File: SF17/21936  
Job ID No: DOC17/559461  
Your Ref: SSD8449

**RE: Heritage Council comments on Locomotive Workshops (Bays 5-13 and 15) Australian Technology Park (SSD 8449); and, Locomotive Workshops (Bays 1-4a) Australian Technology Park (SSD 8517)**

Roof Annex Signage Zones Elevation

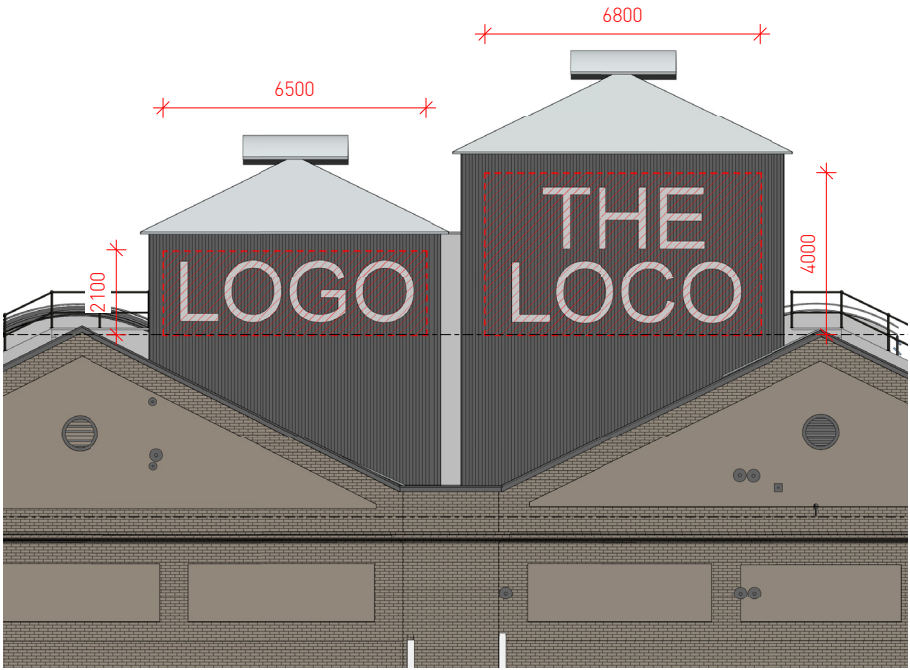
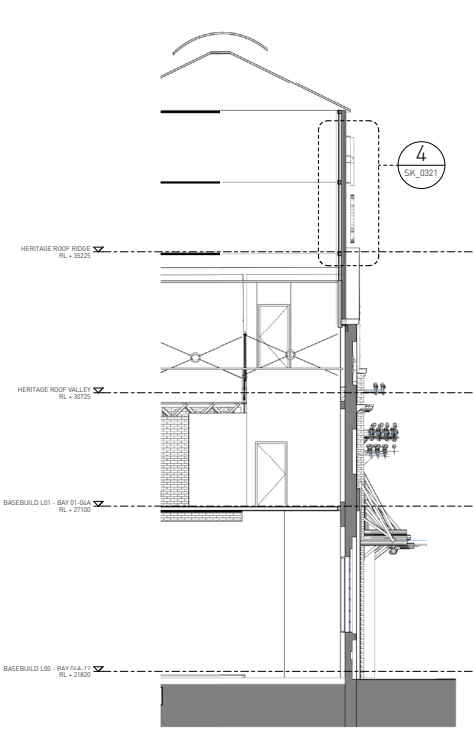
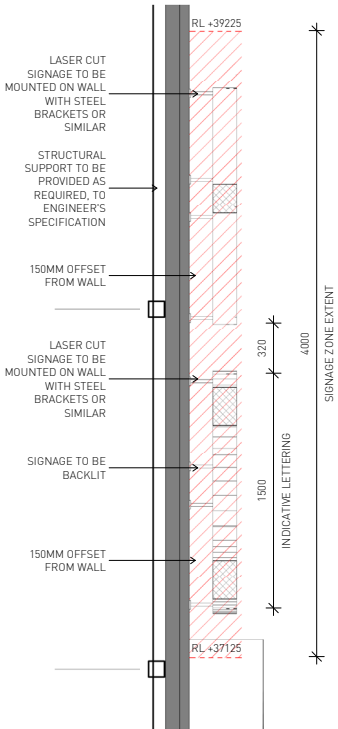
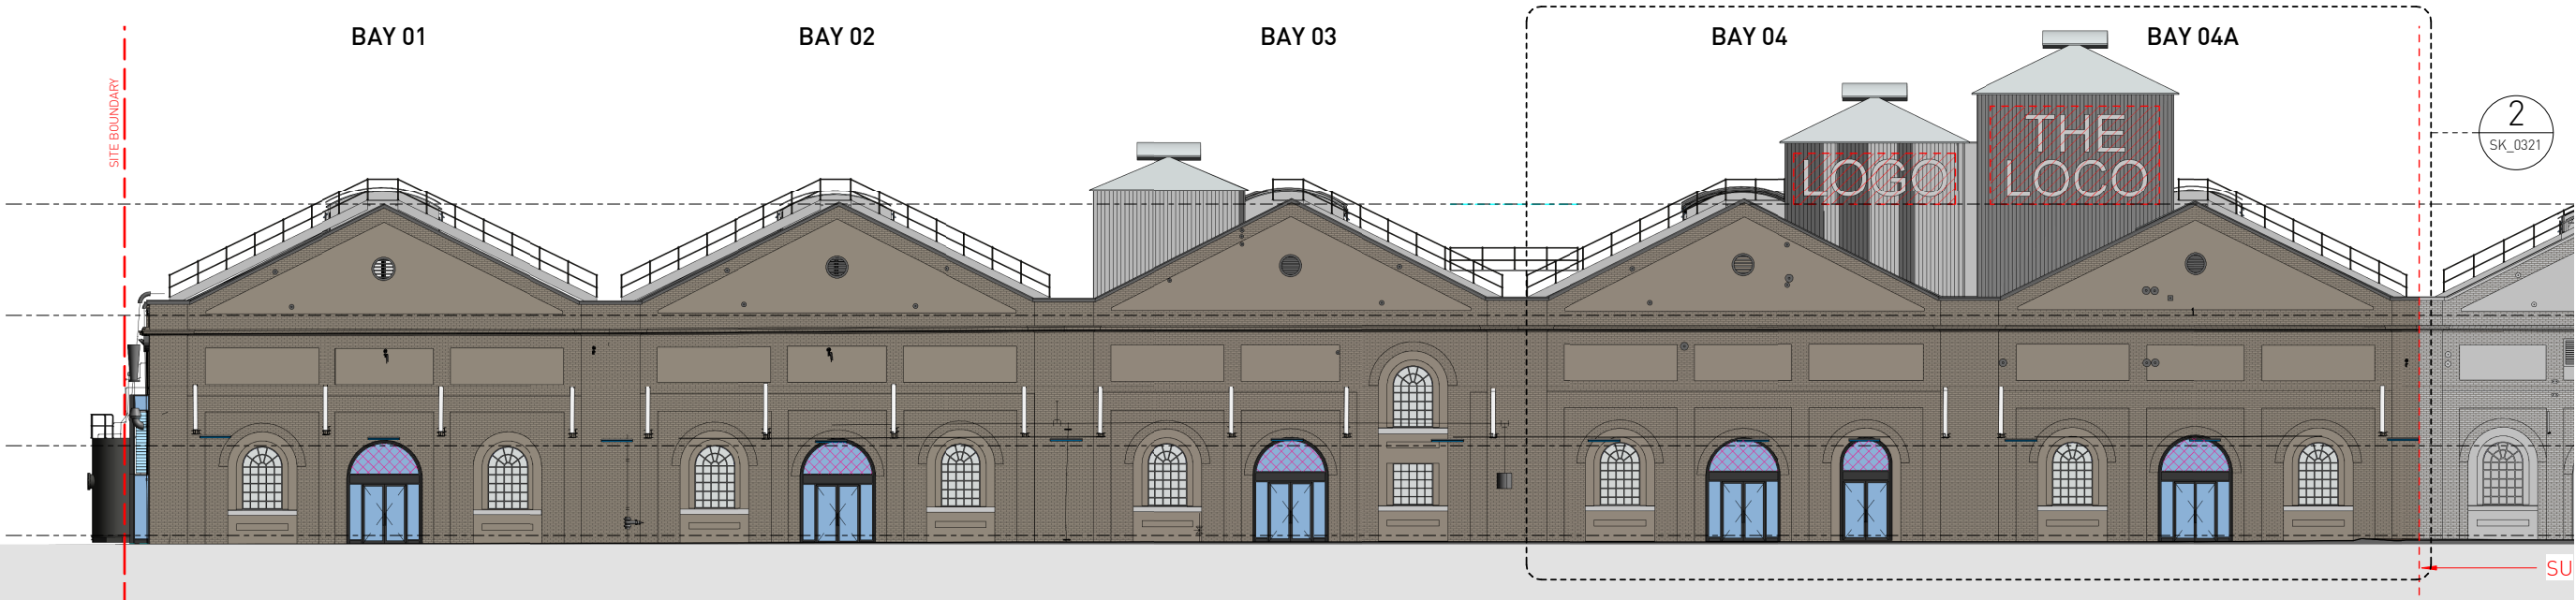
- r) Multiple signage zones have been identified on elevations including above entry access ways and on service towers. It is understood the signage plan will be subject to a separate application. However, it is recommended that the location of these zones be reviewed, in particular the zones located on the service towers. Signage in this location has the potential to have adverse impacts on the building aesthetic. In addition, it is recommended that the signage plan be developed as part of the interpretation strategy to ensure signage is visually consistent and specifically designed to respect the integrity of the industrial character of the place.

1 INTERTENANCY WALL PLAN
1:100

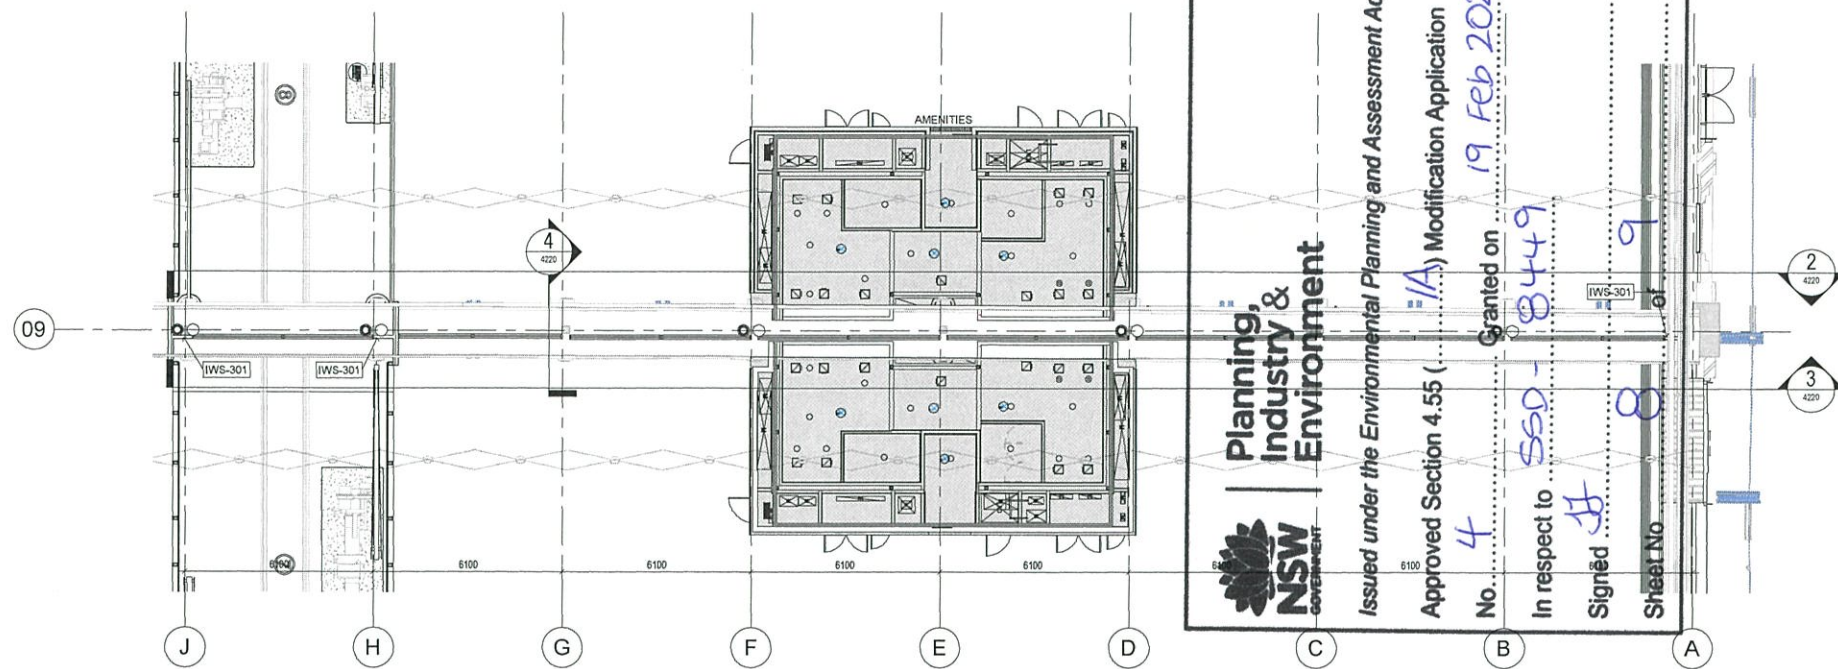
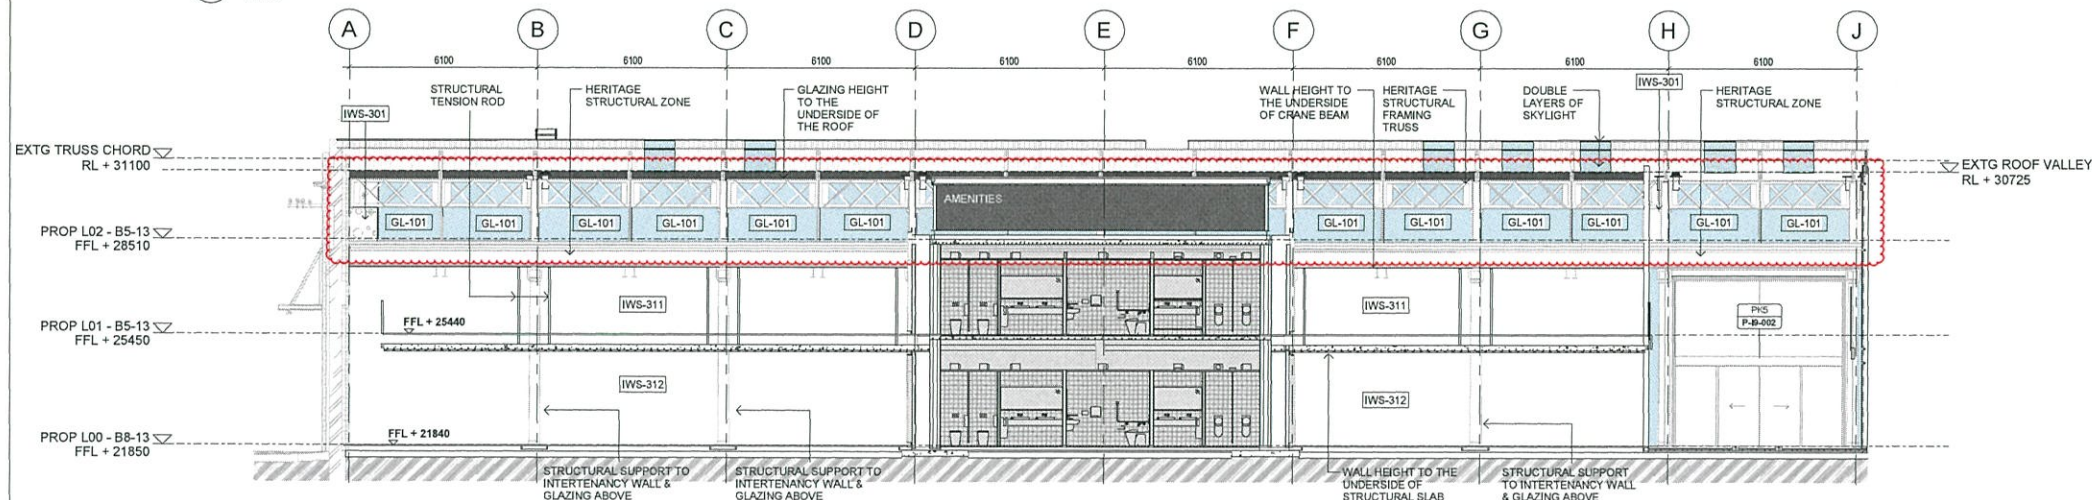
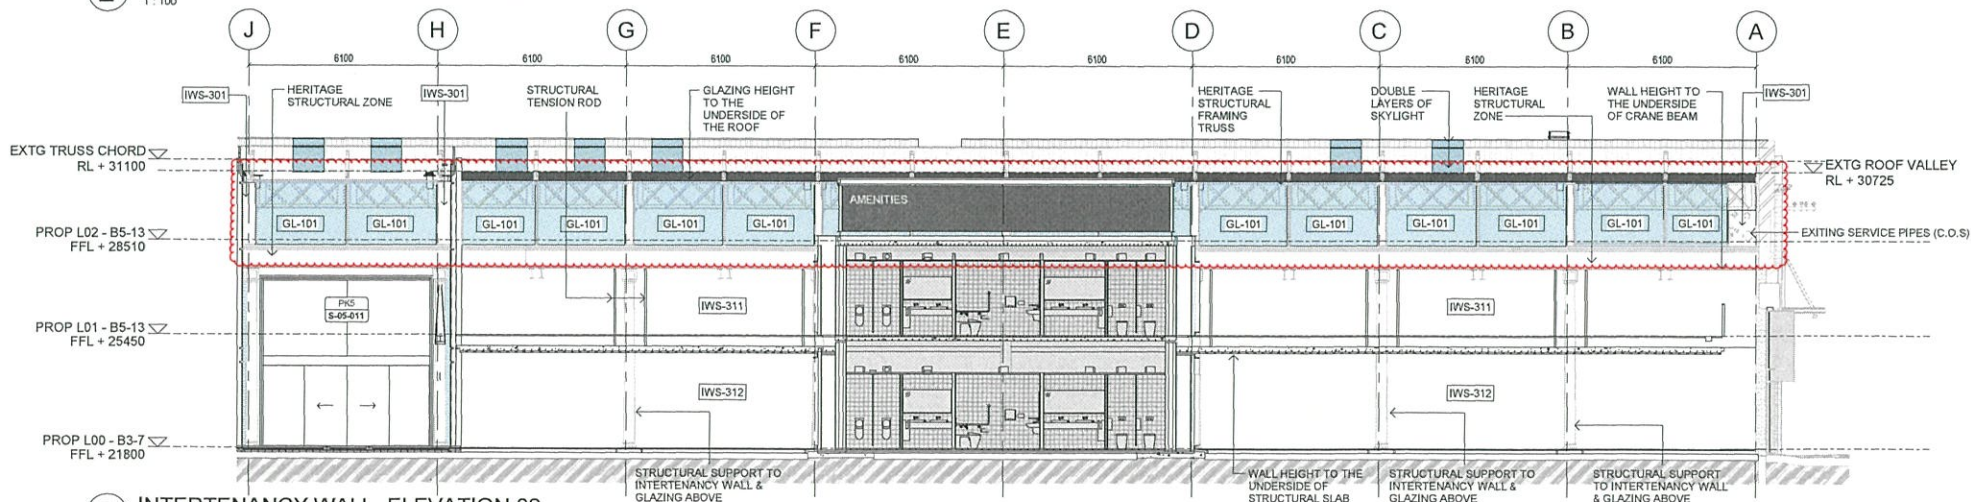
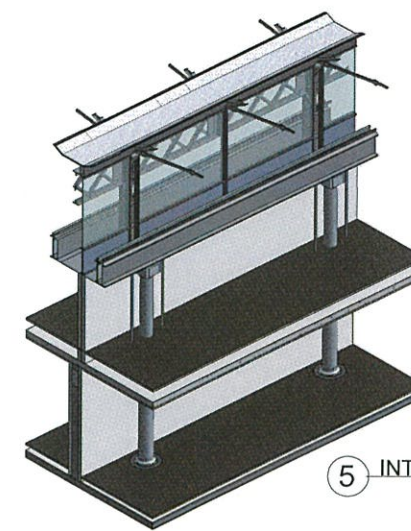
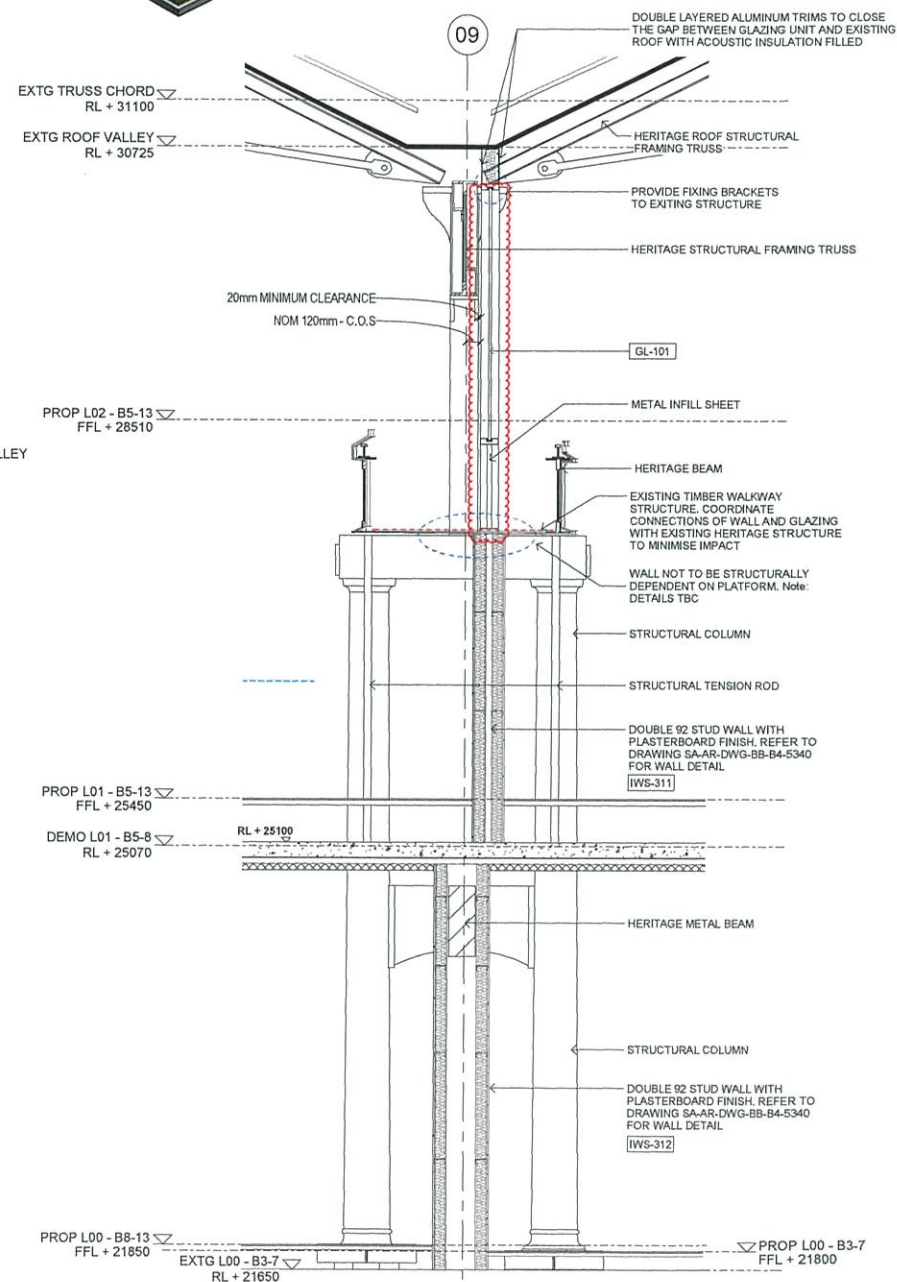
- l) New intertenancy walls are proposed to cross the central east-west spine for fire compartmentalisation in Bays 2/3, Bays 4a/5, and Bays 7/8. These are proposed to be infill glazed walls. Consideration should be given to utilising alternative design solutions such as fire curtains, or concealed sliding doors. If these are not suitable, a reduction in framing is recommended to make these intertenancy walls as transparent as possible and retain the important east-west access view line to enable the large volume of the space to be understood.
